## *Rezoning Petition Review*

**Date of Review:** December 17, 2007 (*Revised February 8, 2008*)

**Rezoning Petition #:** 08-35

SP101

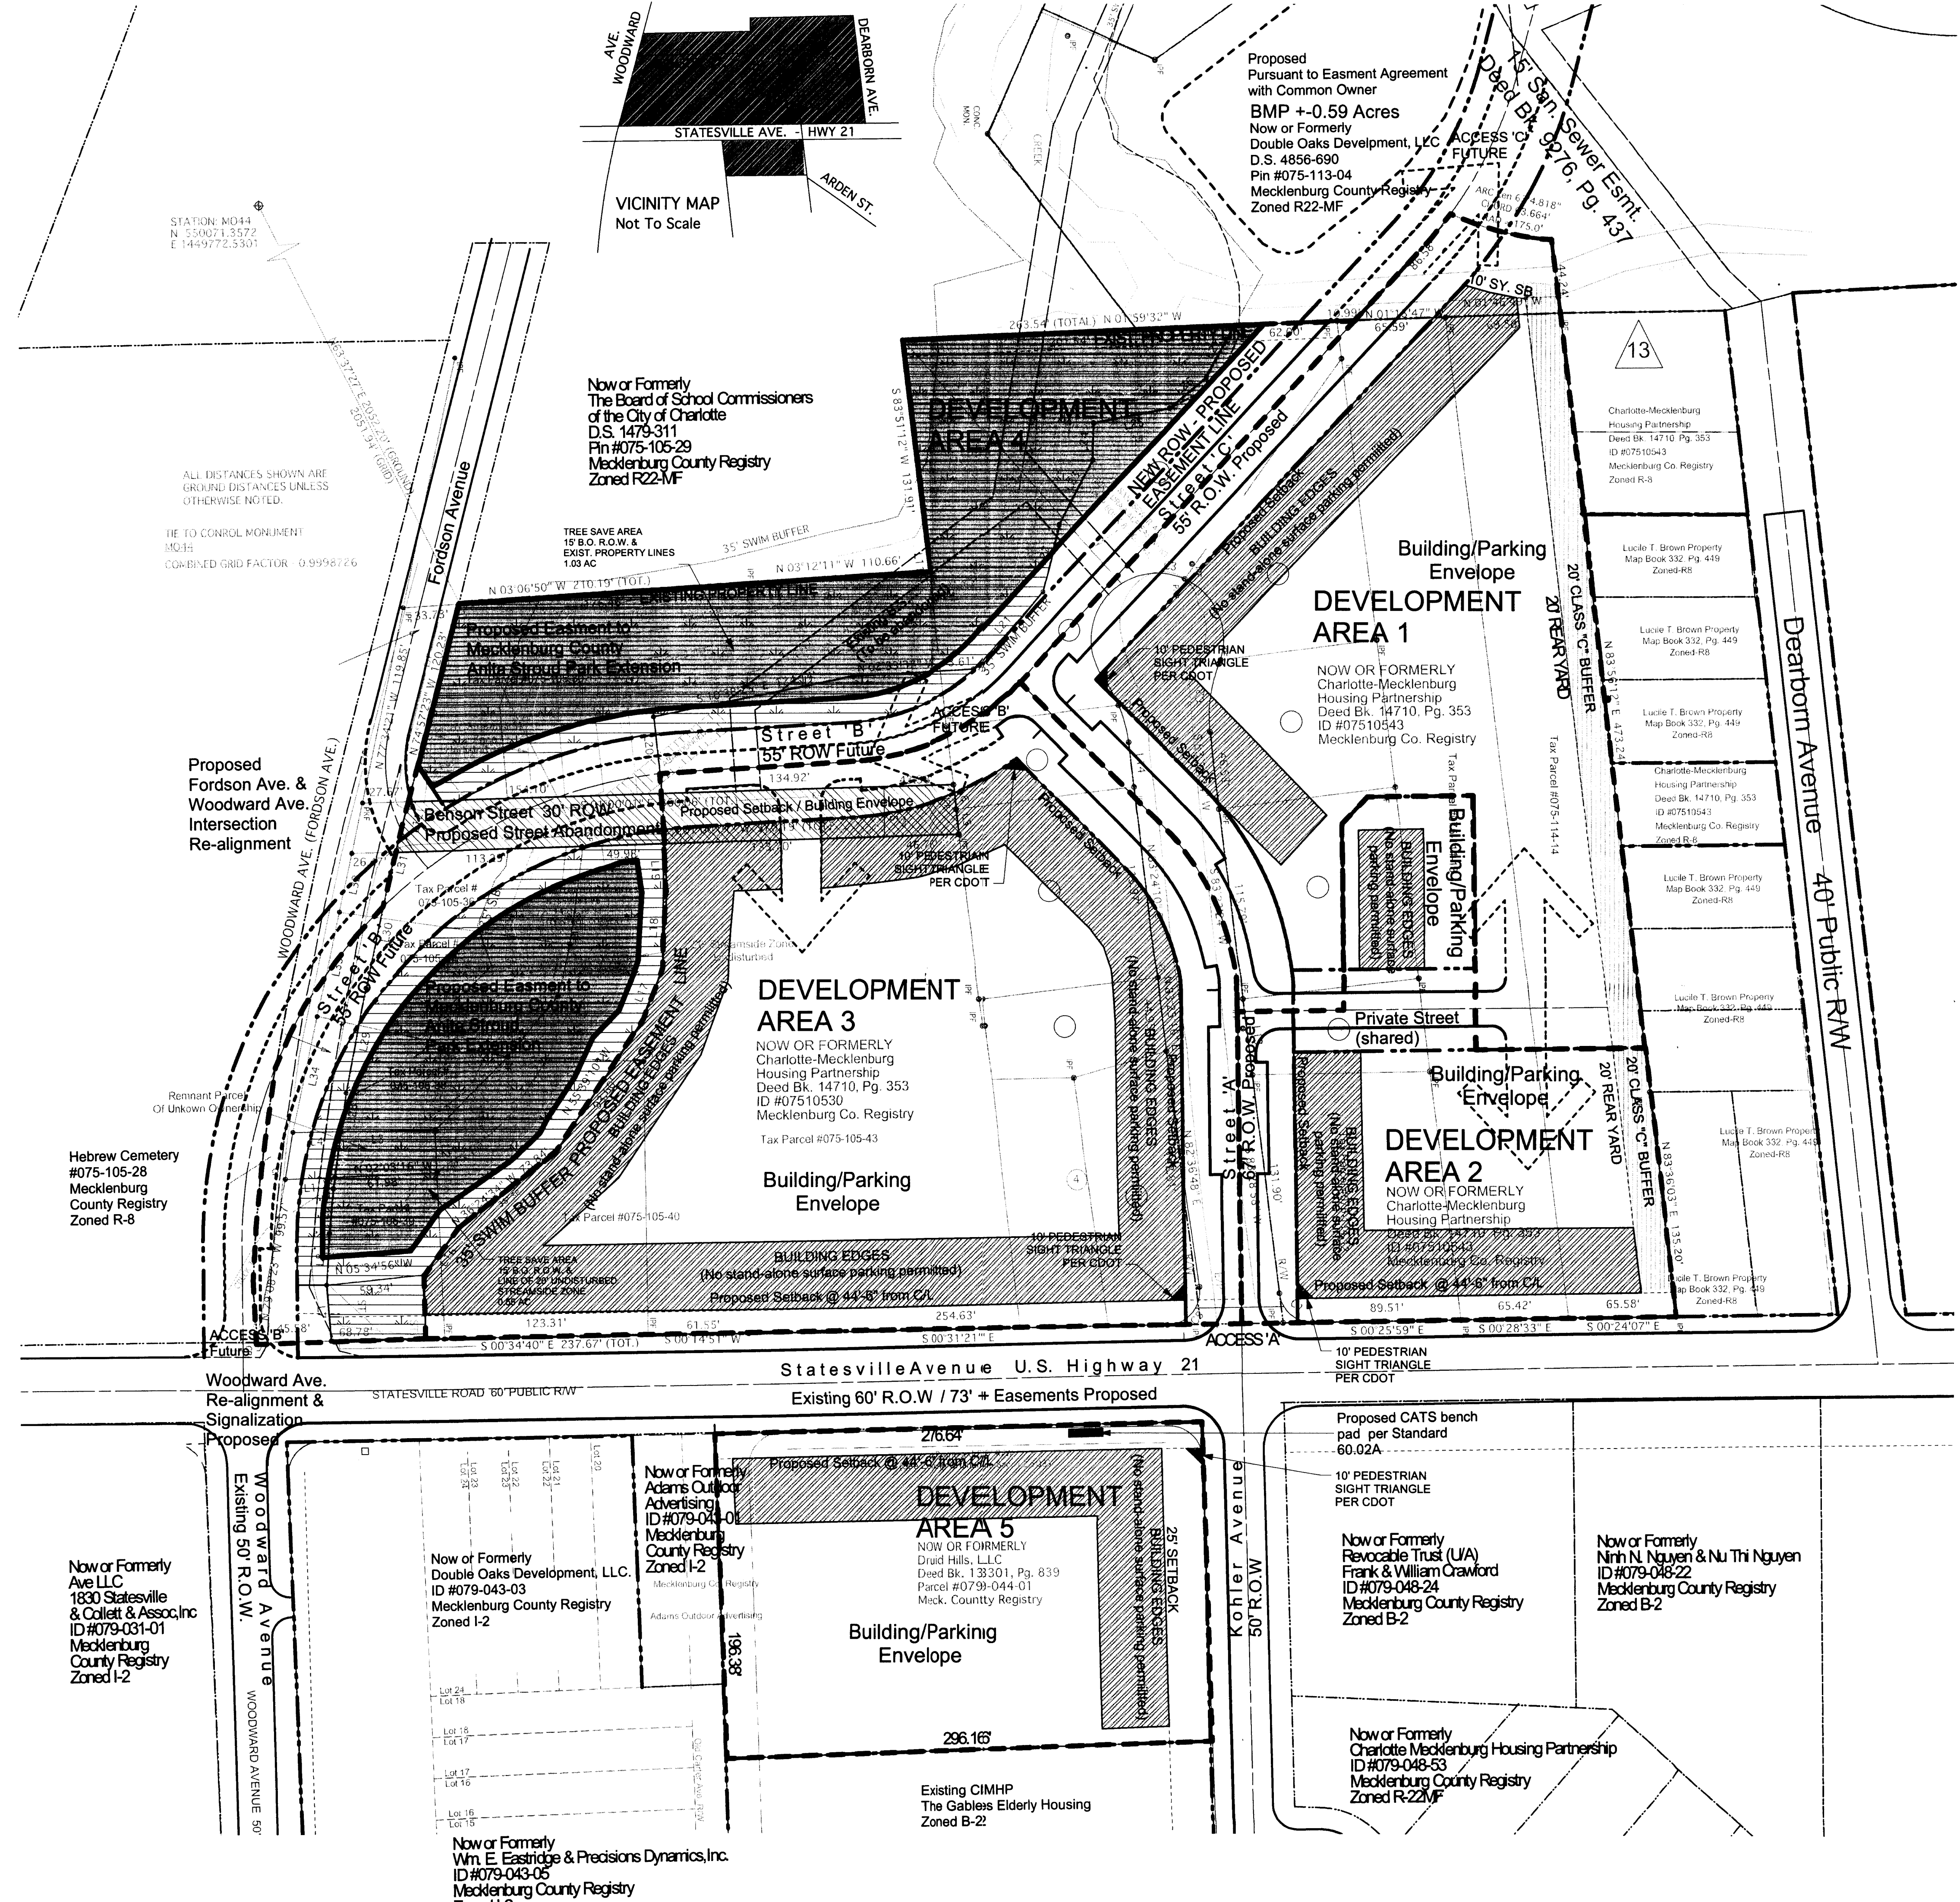
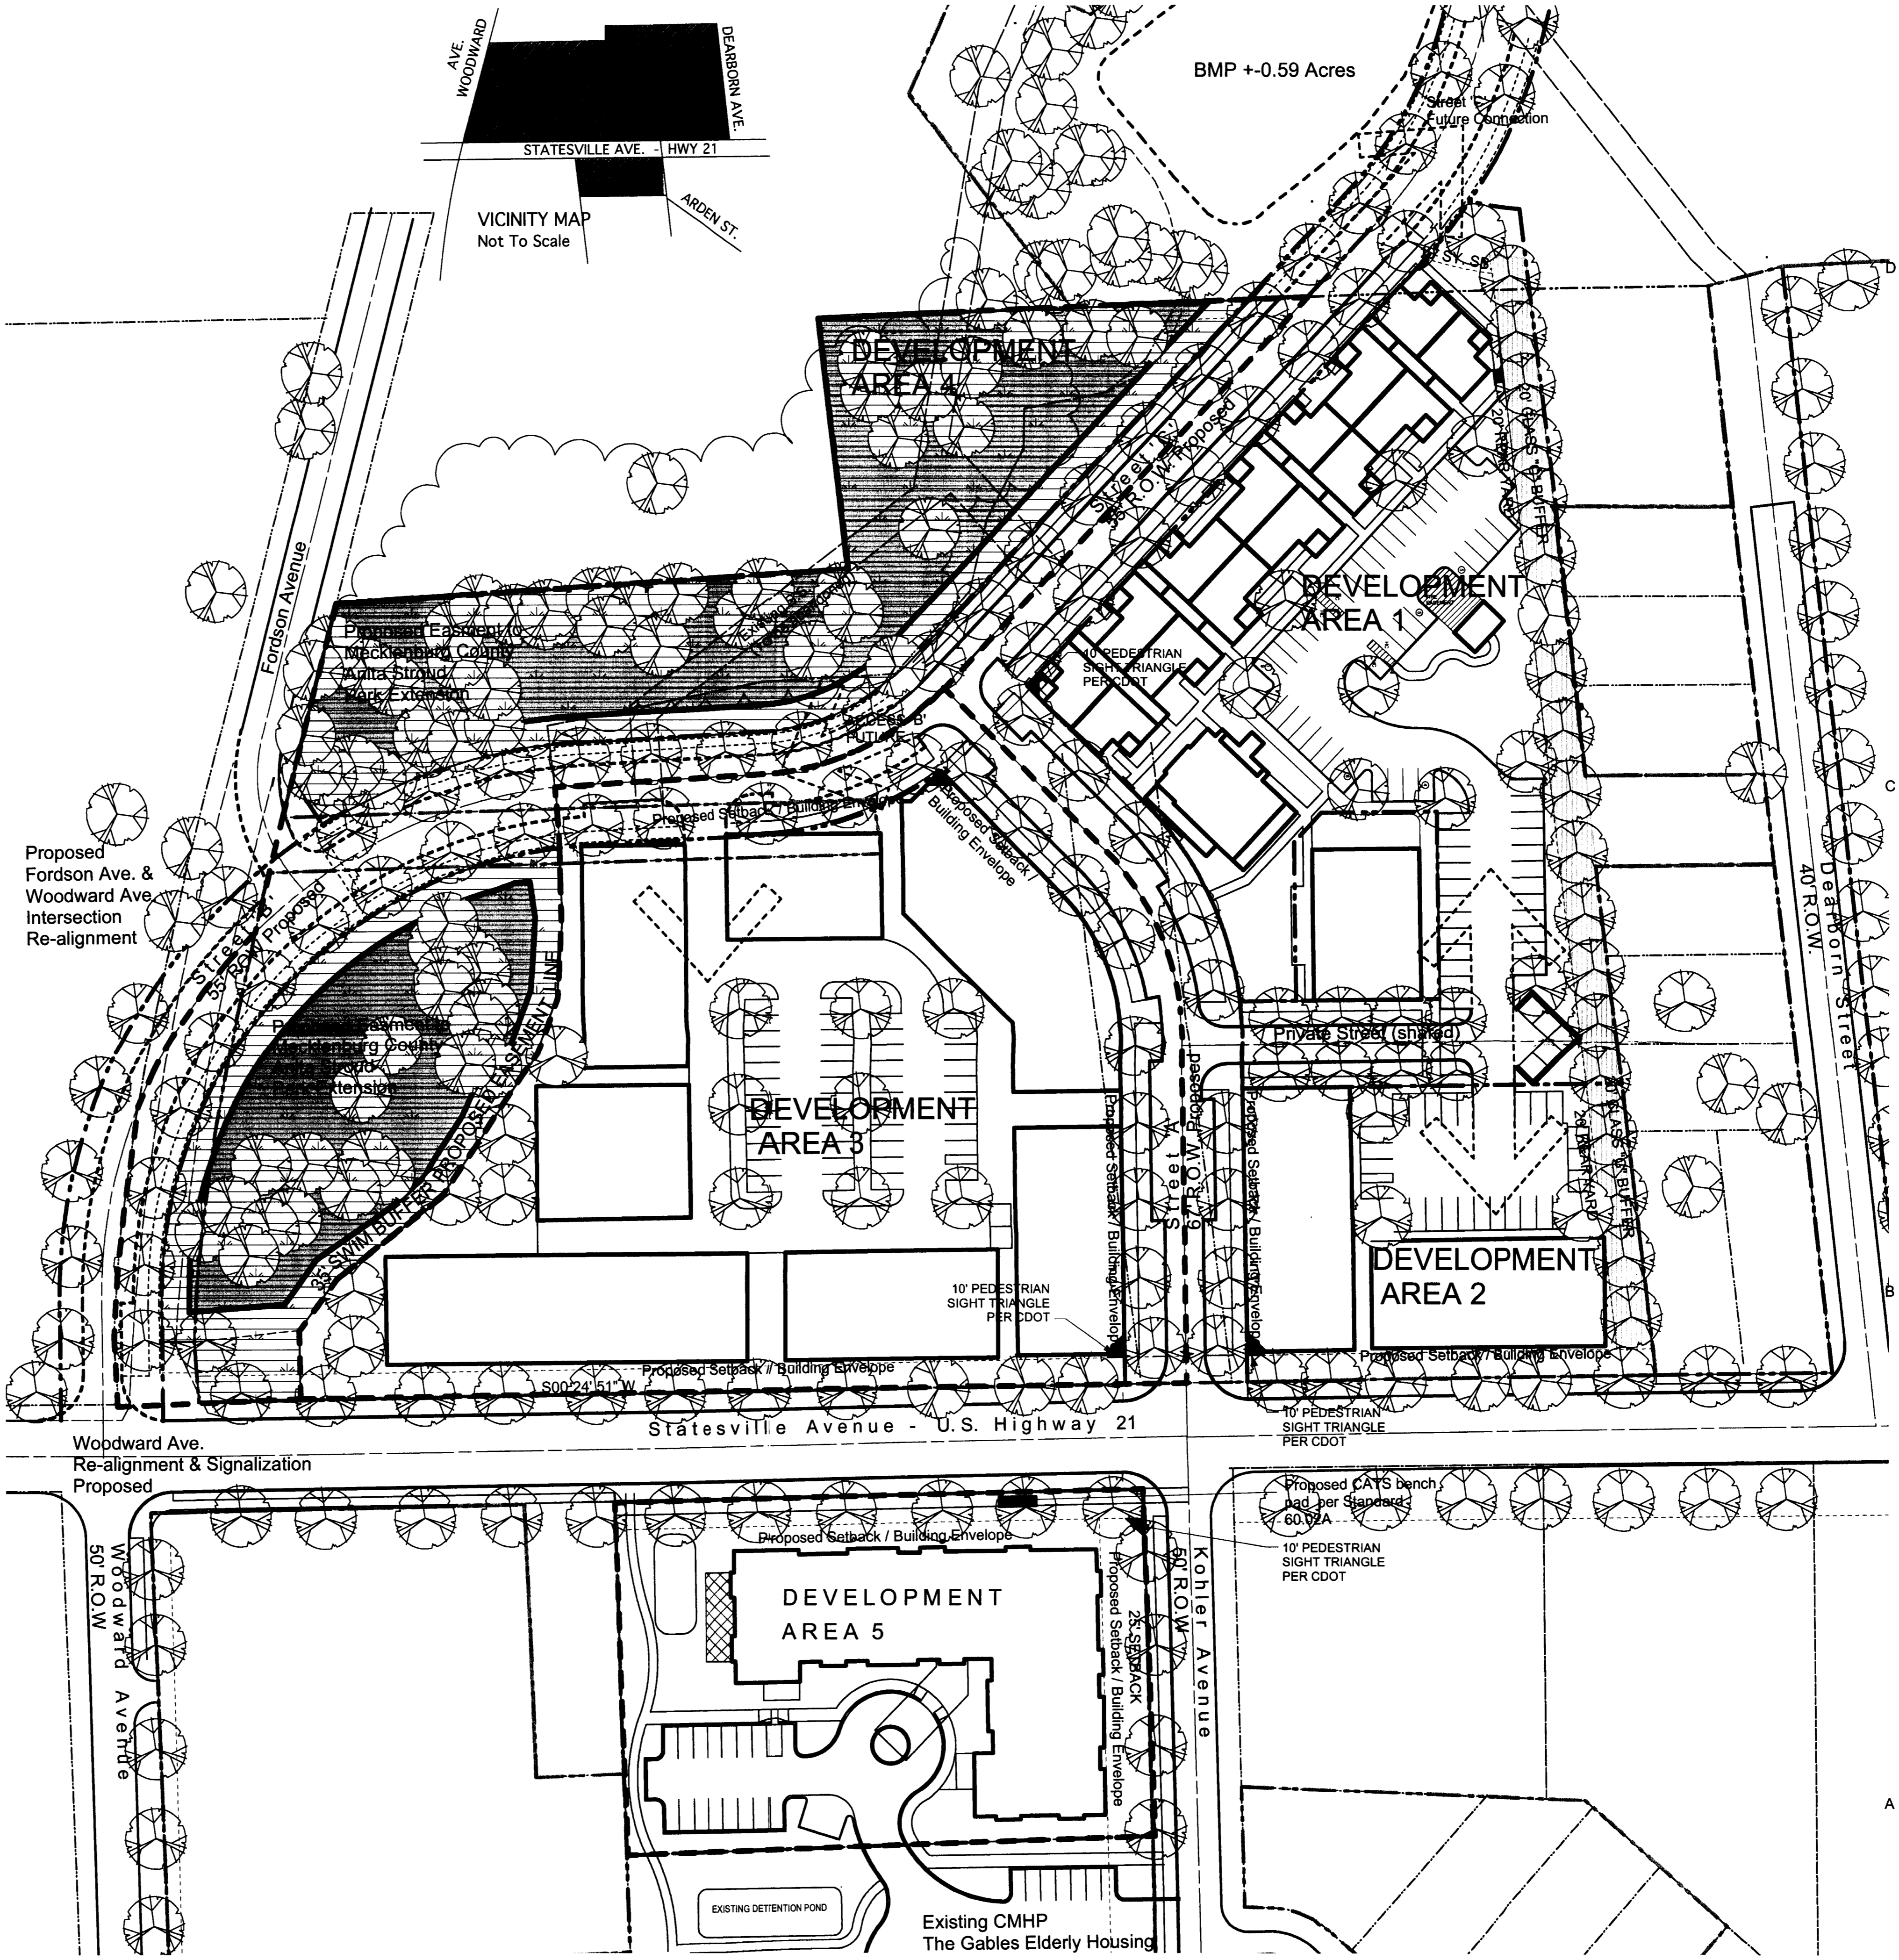
***The petitioner shall remove note 10.3 in its entirety and replace with the following notes:***

Storm Water Quality Treatment – Source: BMP recommendation taken from "Post-Construction

For projects with defined watersheds greater than 24% built-upon area, construct water quality best management practices (BMPs) to achieve 85% Total Suspended Solid (TSS) removal for the entire post-development runoff volume for the runoff generated from the first 1-inch of rainfall. BMPs must be designed and constructed in accordance with the Mecklenburg County BMP Design Manual, July 2007 or North Carolina Division of Water Quality Stormwater Best Management Practices Manual, July 2007. (Design Standards shall be met according to the City of Charlotte Best Management Practices Manual, when available). Use of Low Impact Development (LID) techniques is optional.

For projects with defined watersheds greater than 24% built-upon area, control the entire volume for the 1-year, 24-hour storm. Runoff volume drawdown time shall be a minimum of 24 hours, but not more than 120 hours.

For commercial projects with greater than 24% BUA, control the peak to match the predevelopment runoff rates for the 10-yr, 6-hr storm and perform a downstream flood analysis to determine whether additional peak control is needed and if so, for what level of storm frequency, or if a downstream analysis is not performed, control the peak for the 10-yr and 25-yr, 6-hour storms.

The S.W.I.M. Stream Buffer requirements apply described in the City of Charlotte Zoning Ordinance, Chapter 12. In addition, intermittent and perennial streams within the project boundary shall be delineated by a certified professional using U.S. Army Corps of Engineers and N.C. Division of Water Quality methodology and shall be shown in the site plan submittal along with all buffer areas.

All perennial and intermittent streams draining less than 50 acres shall have a minimum 30-foot vegetated buffer including a 10-foot zone adjacent to the bank. Disturbance of the buffer is allowed; however, any disturbed area must be re-vegetated and disturbance of the 10-foot zone adjacent to the bank shall require stream bank stabilization using bioengineering techniques as specified in the Design Manual.
